# The Planning Inspectorate Yr Arolygiaeth Gynllunio

Our Ref: EN010112

### **Application by Awel y Môr Offshore Wind Farm Limited for an Order Granting Development Consent for the Awel y Môr Offshore Wind Farm**

#### **Advice following issue of decision to accept the application for examination**

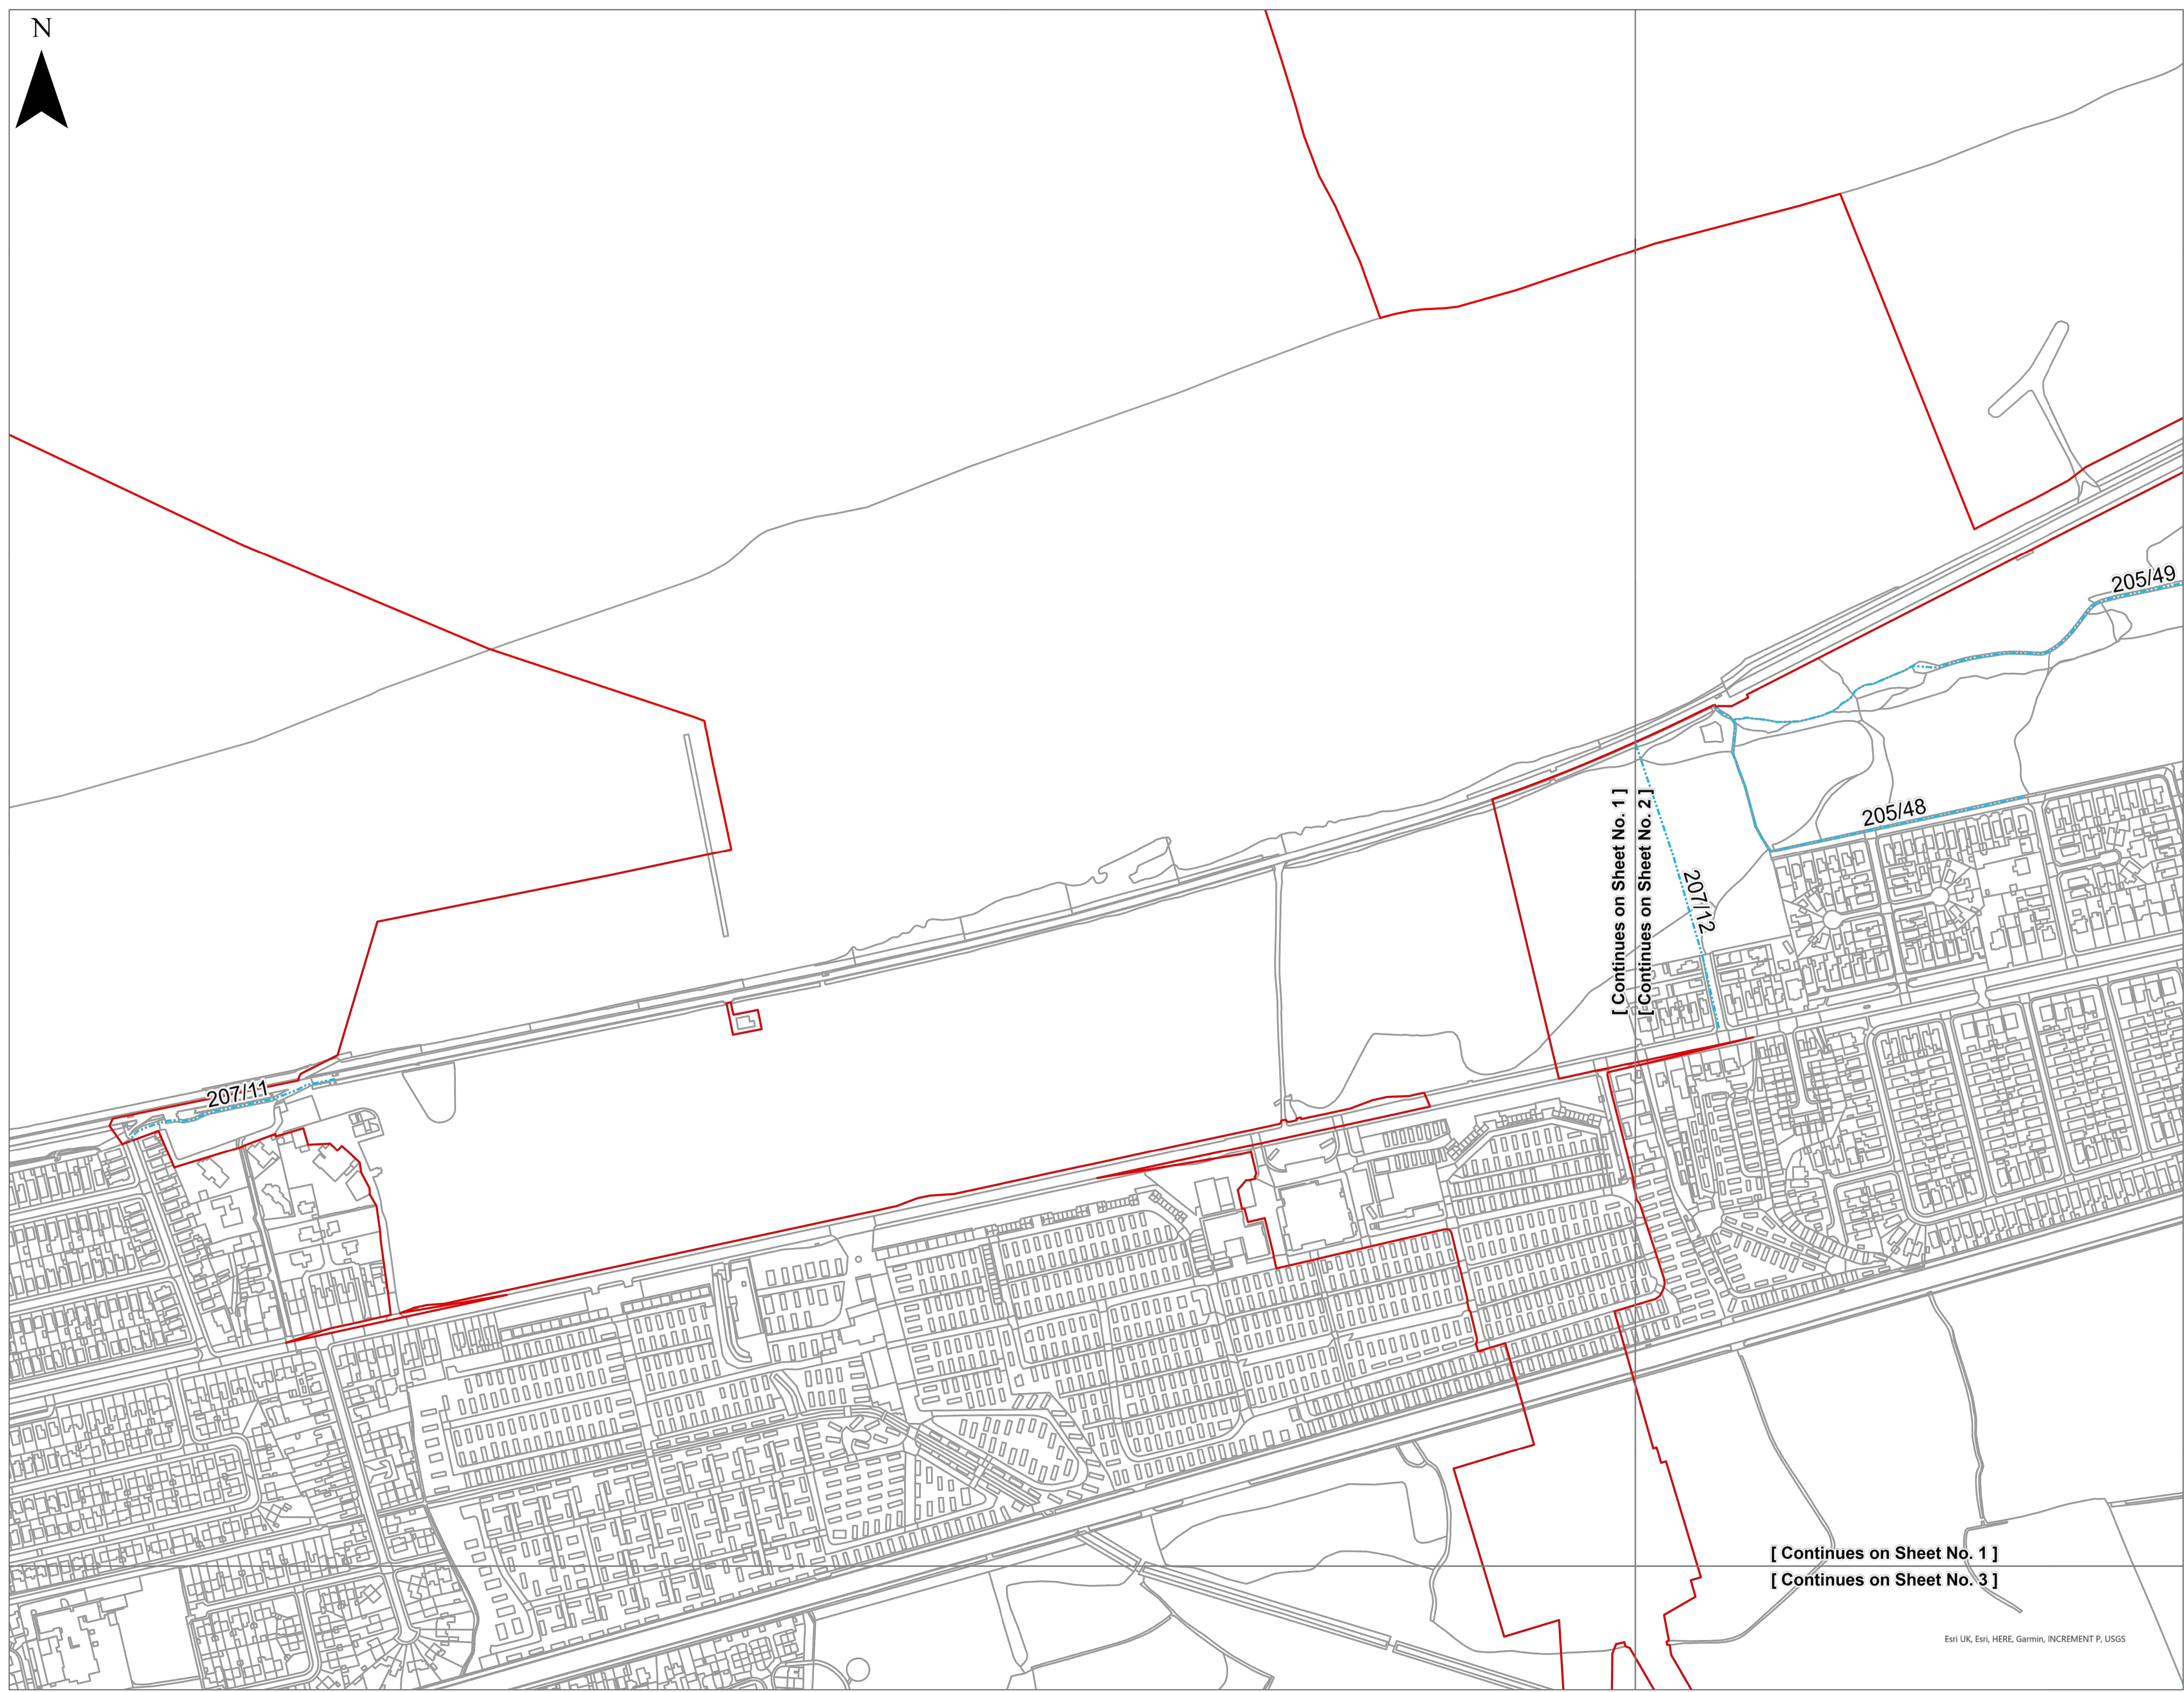
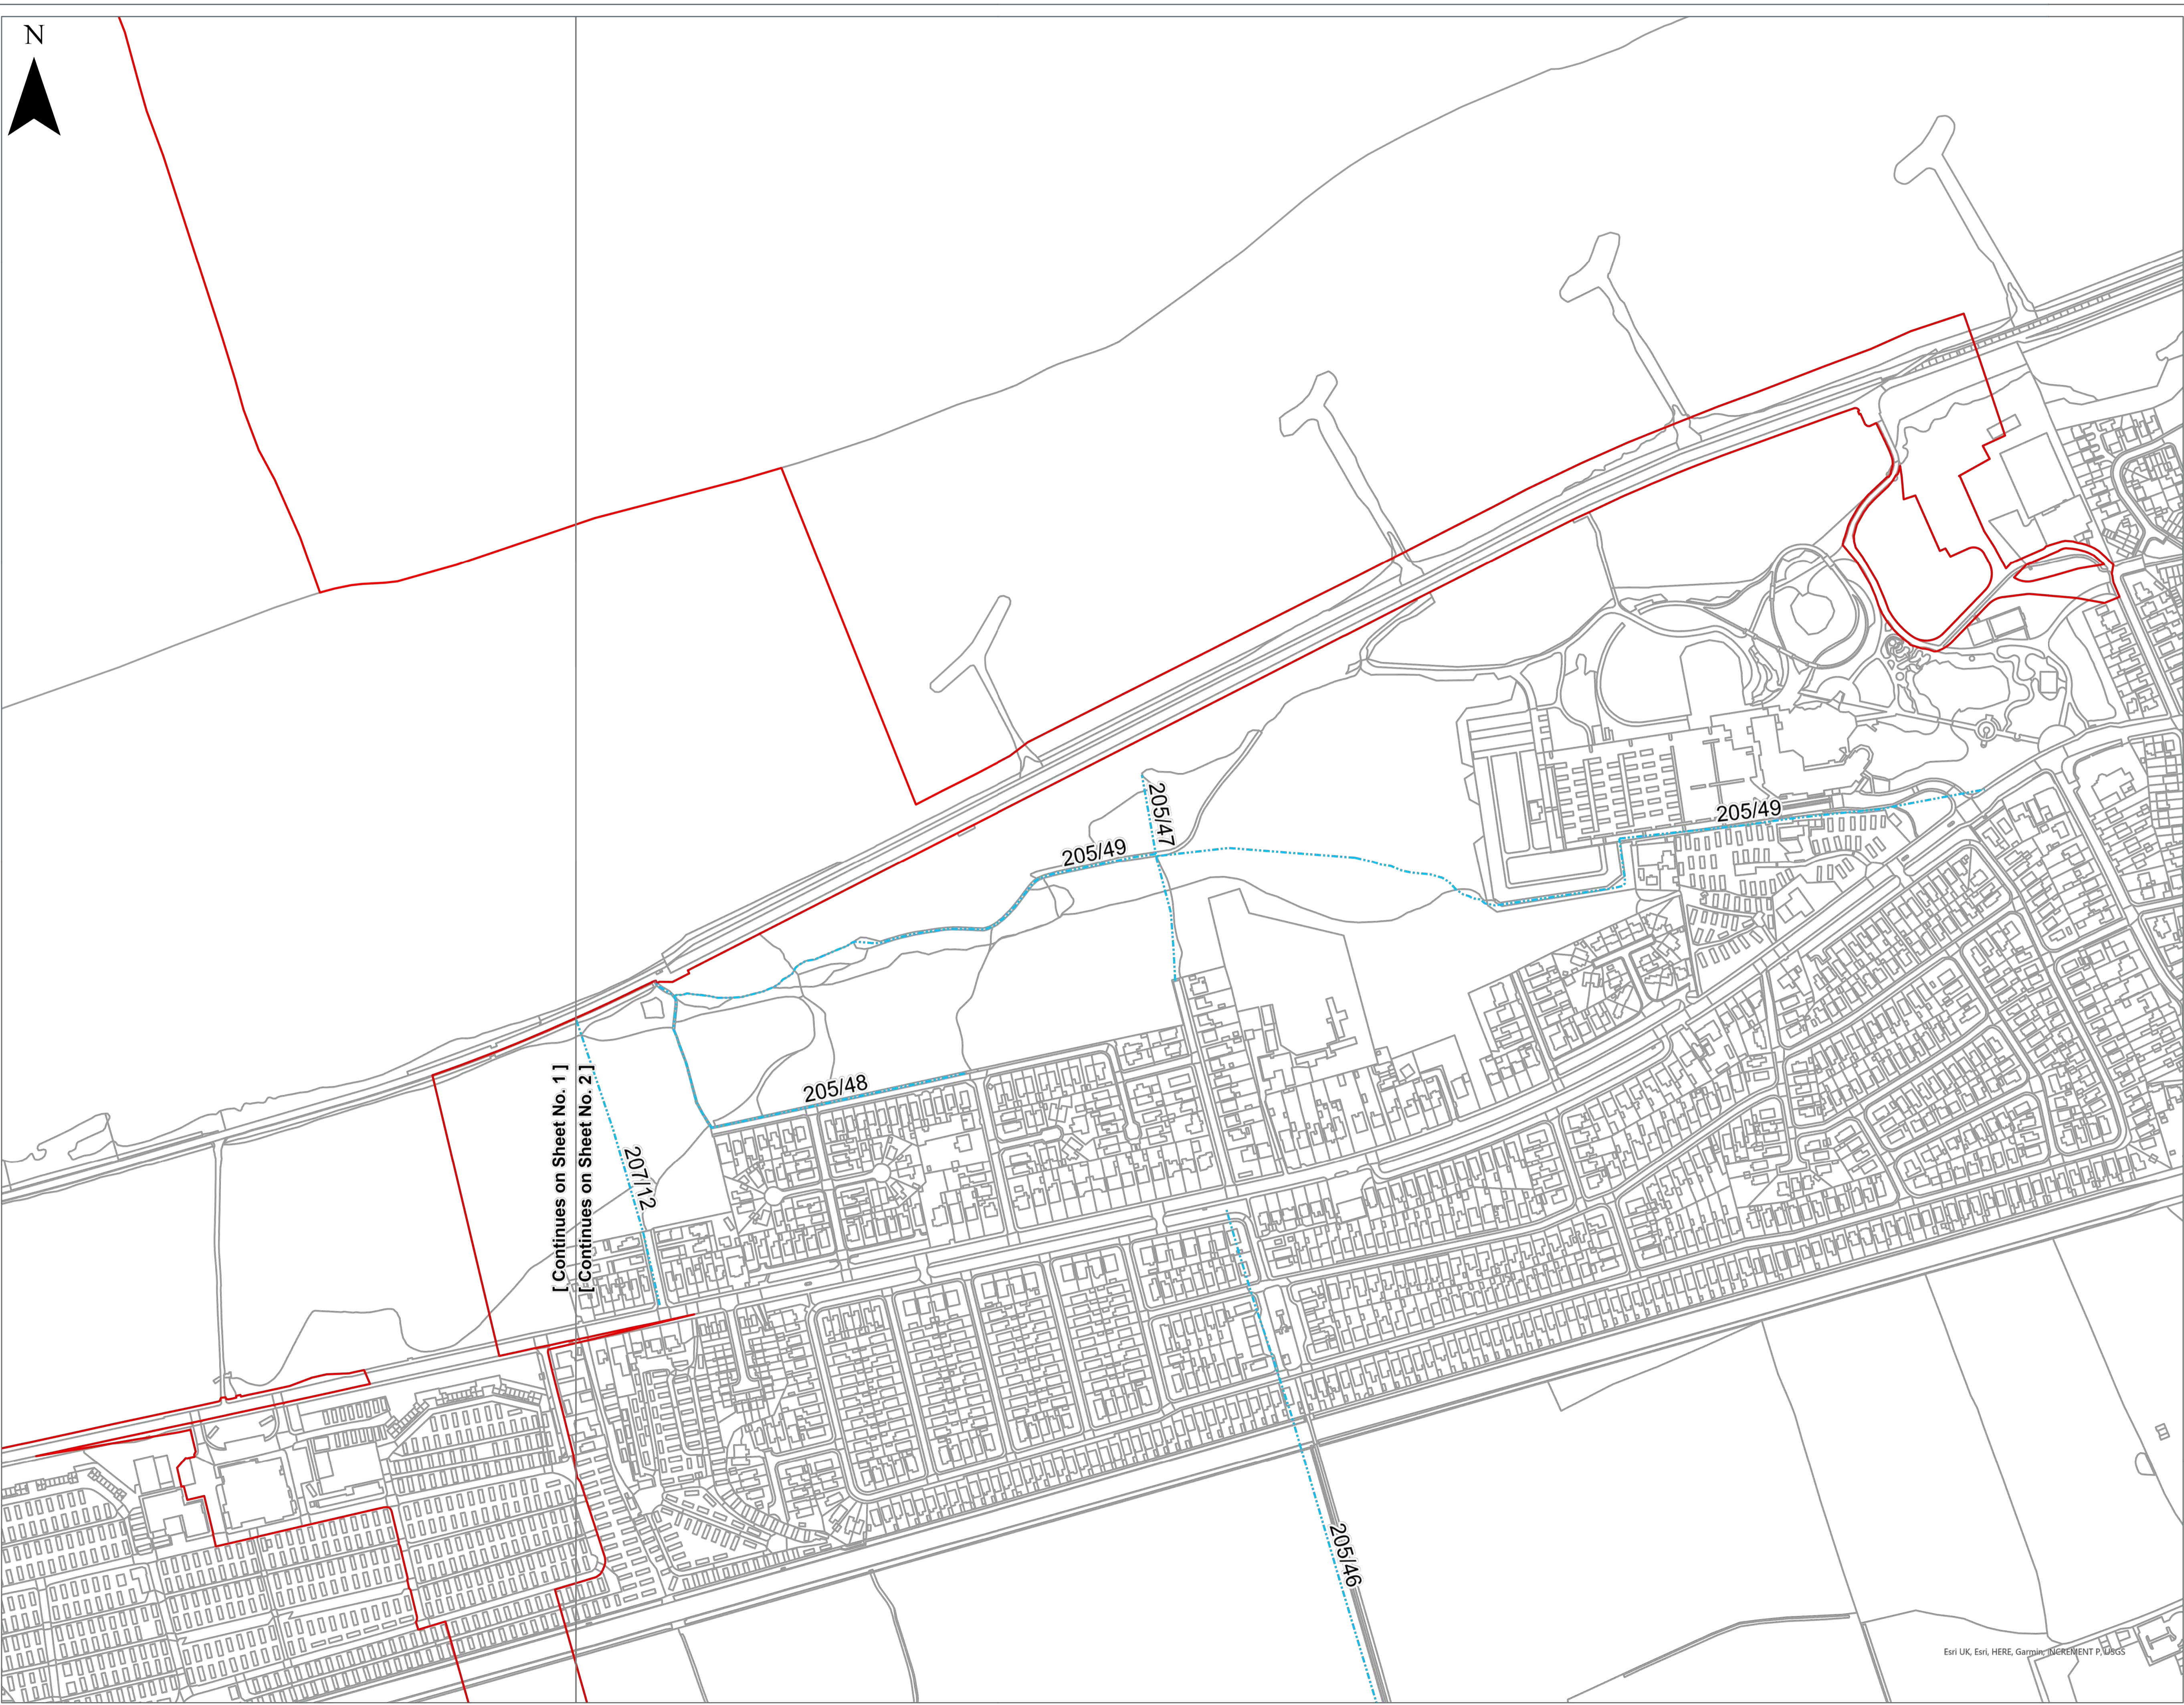
- The legend in the Street Works and Access Plan refers to Schedule 4 instead of Schedule 3 of the dDCO.
- Footpath names on the Temporary Stopping Up of Public Rights of Way Plans could be enlarged.

- Schedule 3 – points BI and BJ shown on the last page of the street works and access plan have been omitted.
- Schedule 4, columns 1 and 2 – inconsistencies between the information in these columns and the information shown on the temporary stopping up of public rights of way plan, and the naming of the plan is the 'temporary stopping up of public rights of way plan'.
